Albuquerque Bernalillo County  
Water Utility Authority

***DEVELOPMENT REVIEW BOARD***

**DRB-1007566      Item No. 13      Zone Atlas B-20**

**Project Number:** 1007566  
**Application Number:** 08DRB-70488

Plat of
Lots 25-A and 25-B, Block 16
North Albuquerque Acres
Tract 1, Unit 3
 comprised of
Lot 25, Block 16, North Albuquerque Acres,
Tract 1, Unit 3
 City of Albuquerque
 Bernalillo County, New Mexico
 November 2008

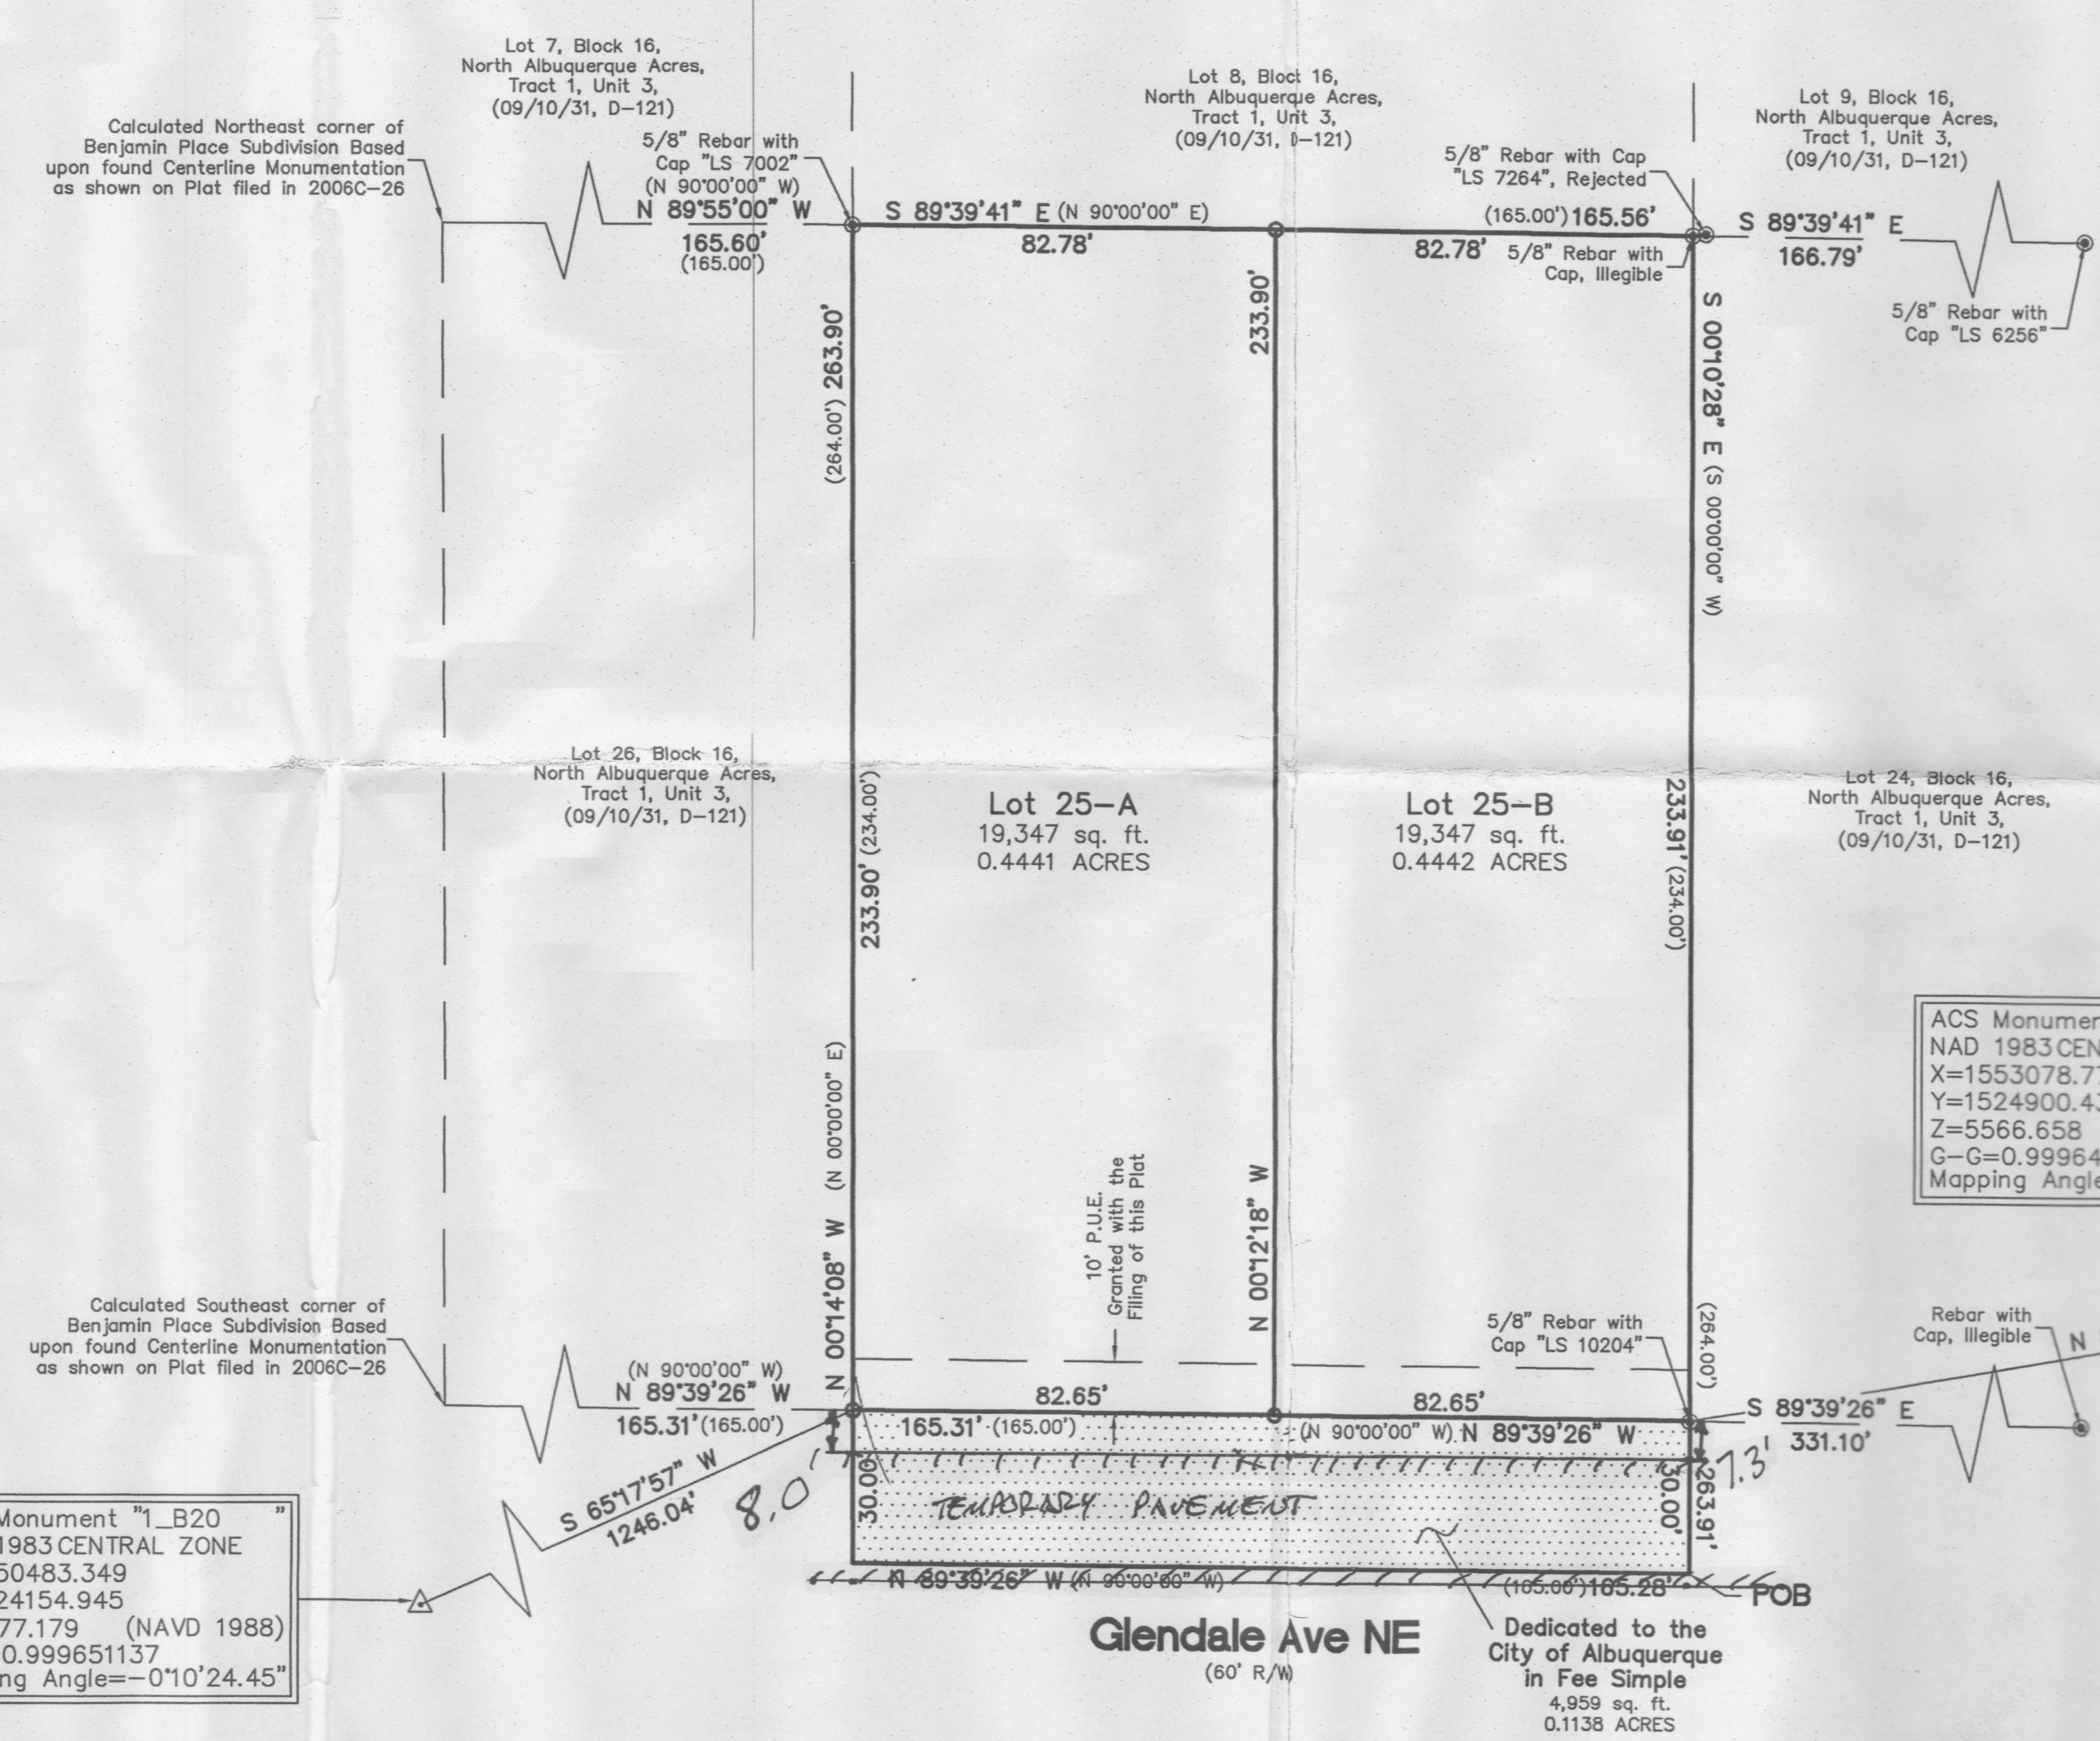
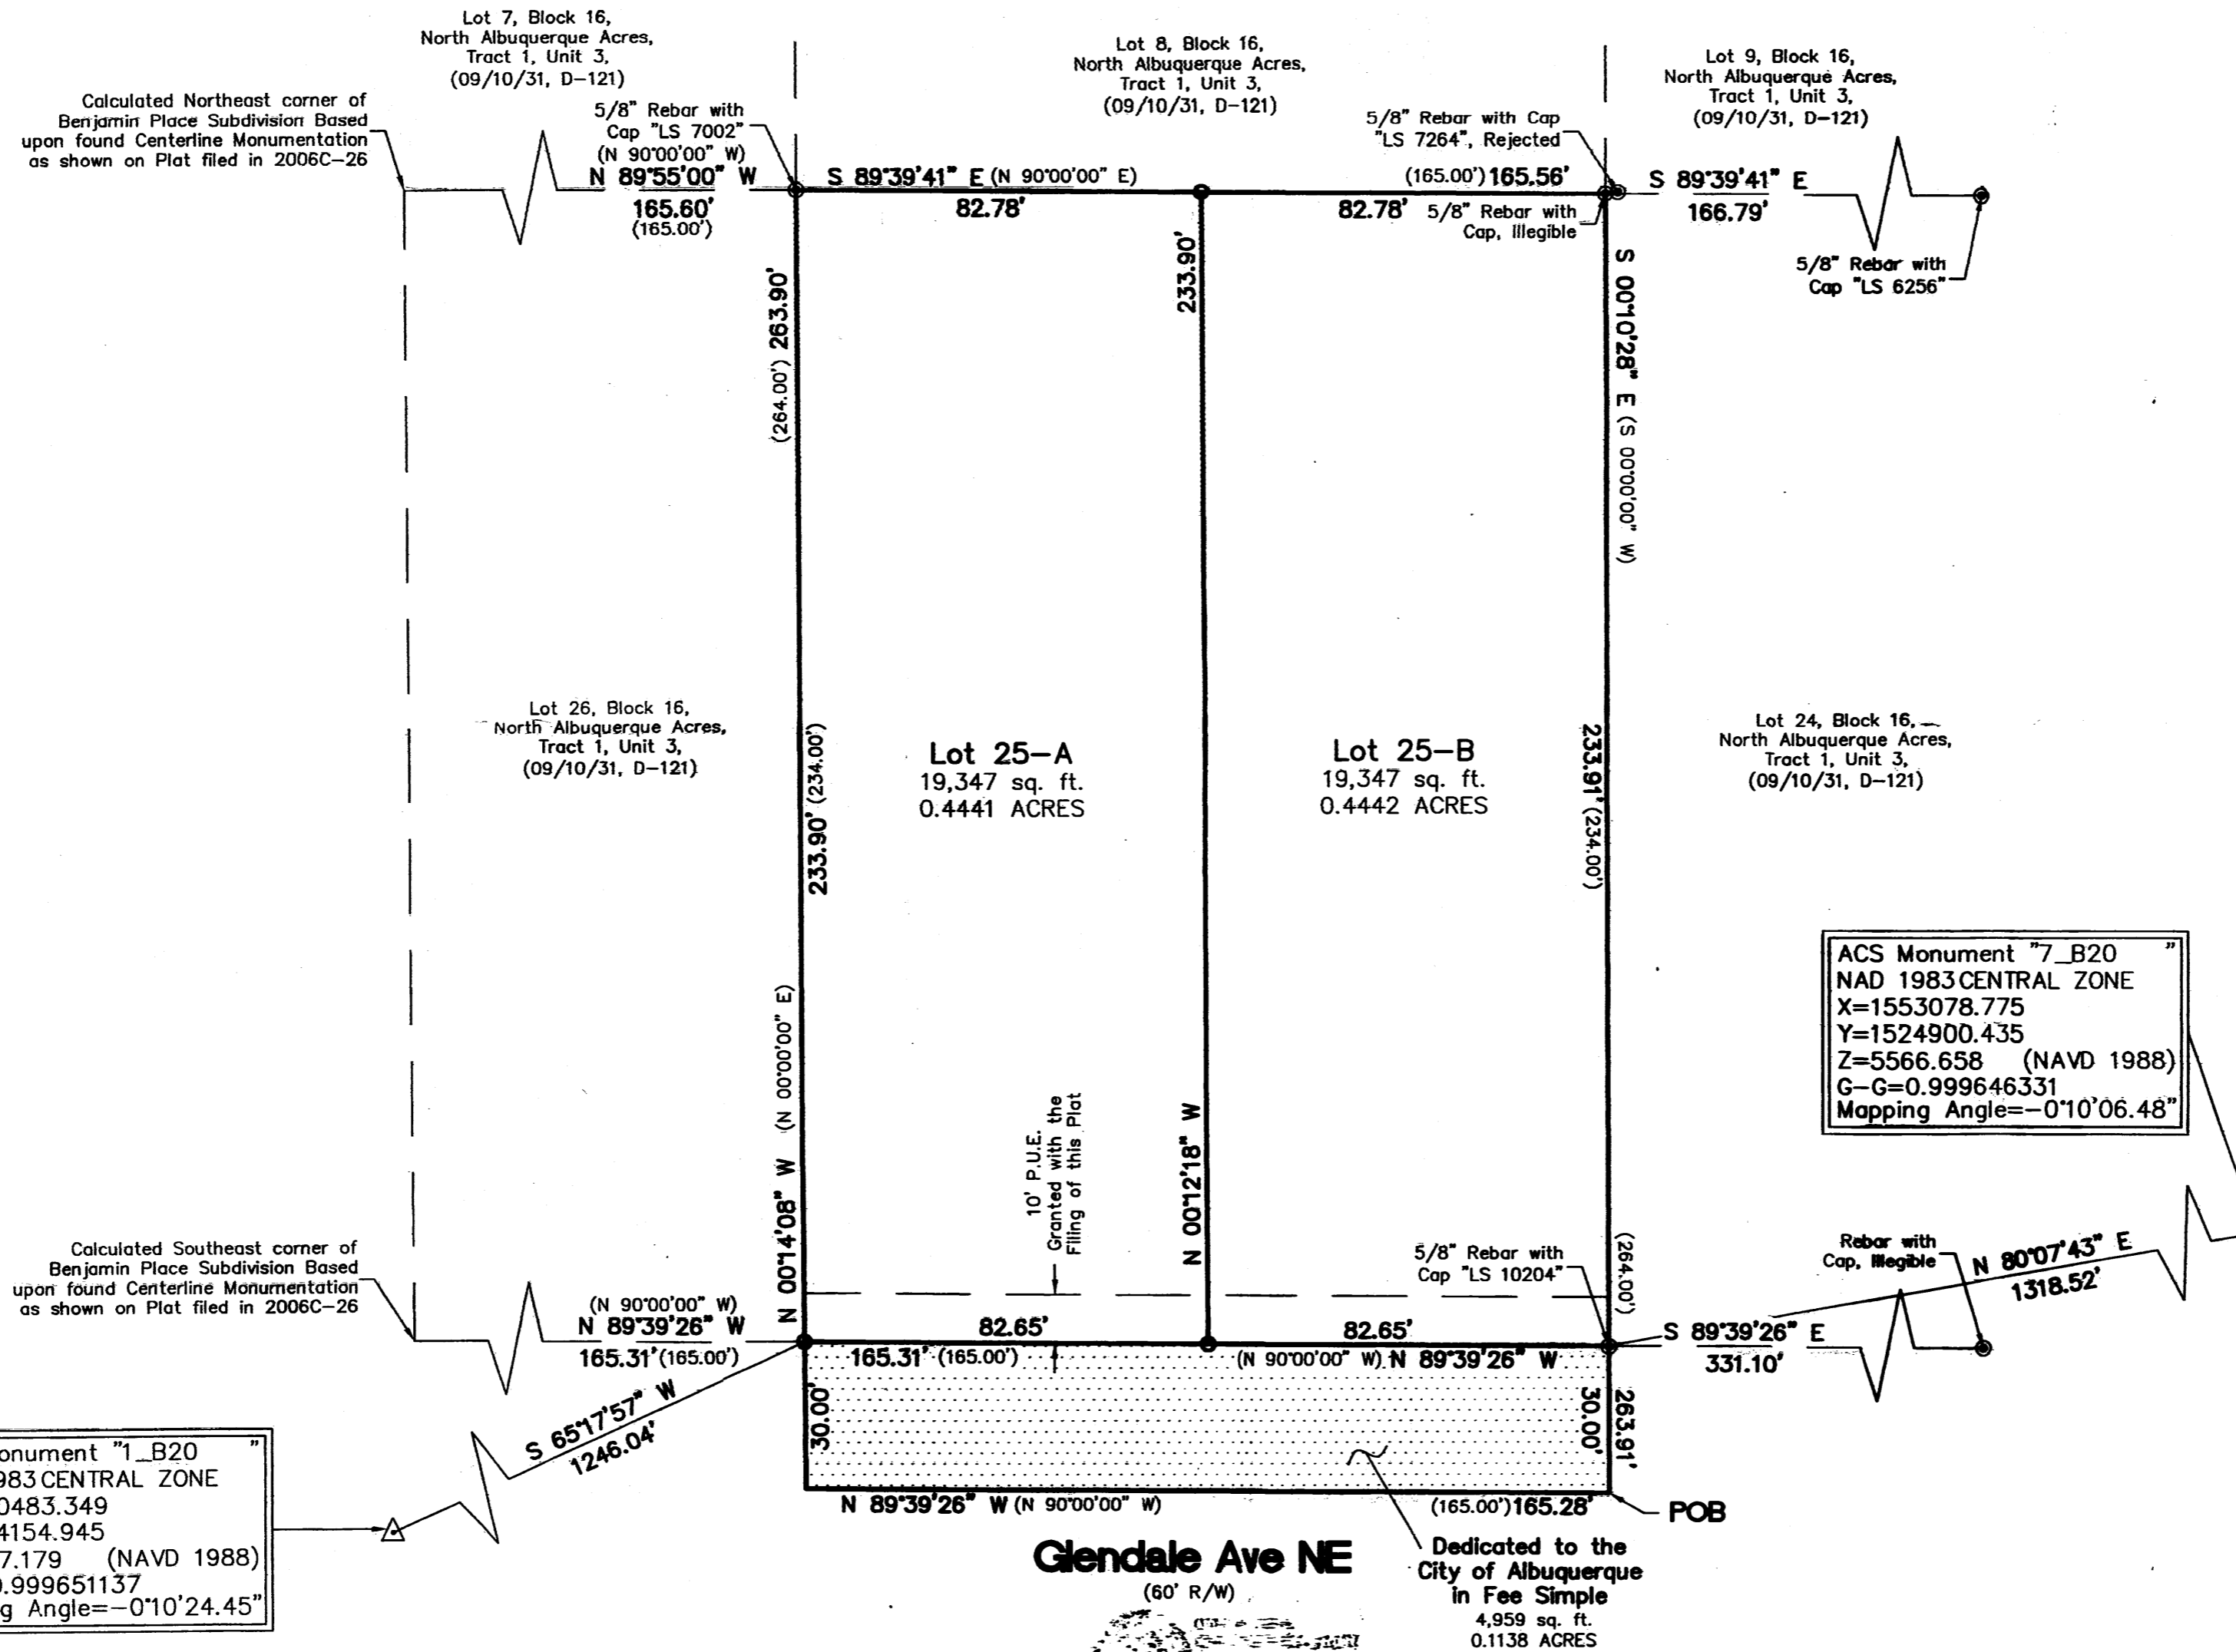
1. Must request a Water/Sewer Availability statement.
2. Lot is within 200' of existing water/sewer lines and extension of lines will be required by Water Authority Ordinances.

The R-D zone requires 2,400 square feet of open space for each dwelling unit. With submittal of the Preliminary Plat/Site Development Plan, provide an Open Space Calculation Table showing the lot number, lot size, building & driveway area, provided open space, remaining open space requirement (this table can be separate from the plat itself). Provide a dimensioned Typical Lot Plan, which shows a typical lot with the building footprint and driveway (this should be on the Site Development Plan rather than the plat). Include one of the following notes on the Preliminary and Final Plats indicating how the total remaining open space requirement will be met:
